COLORADO
Department of Transportation

SH 94A
El Paso County

RE: Black Hills Energy - Highway 94 Enoch Road - Mayberry
CDR2117 | Construction Drawing Review

T23 TYPICAL ROAD CROSSING
C541 NO SCALE

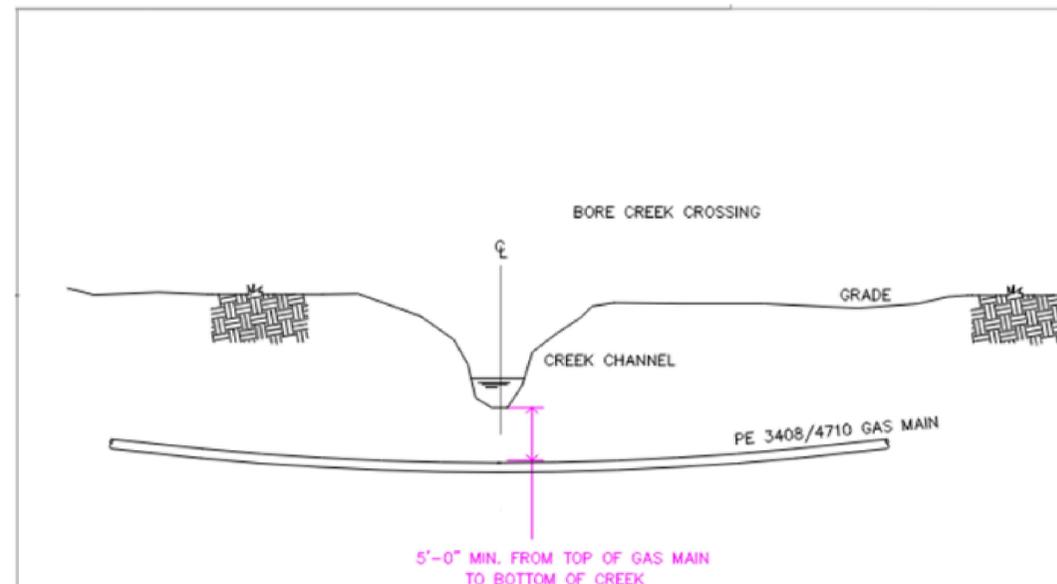
- A CDOT Utility Permit is required prior to start of project. Contact Gabe Martinez with CDOT Utilities Permitting for Utility Permitting review of plans and specifications required.
- Per CDOT Utilities the bore under the State Highway is allowed.
- Minimum cover at the lowest point of the bore is required to be a minimum of 48-inches and maintained for the complete bore measured at the top of pipe. The plans show deeper grades of 6-foot and 5-foot and that is preferred.
- 3-foot depth bores at the Right of Way are not allowed.
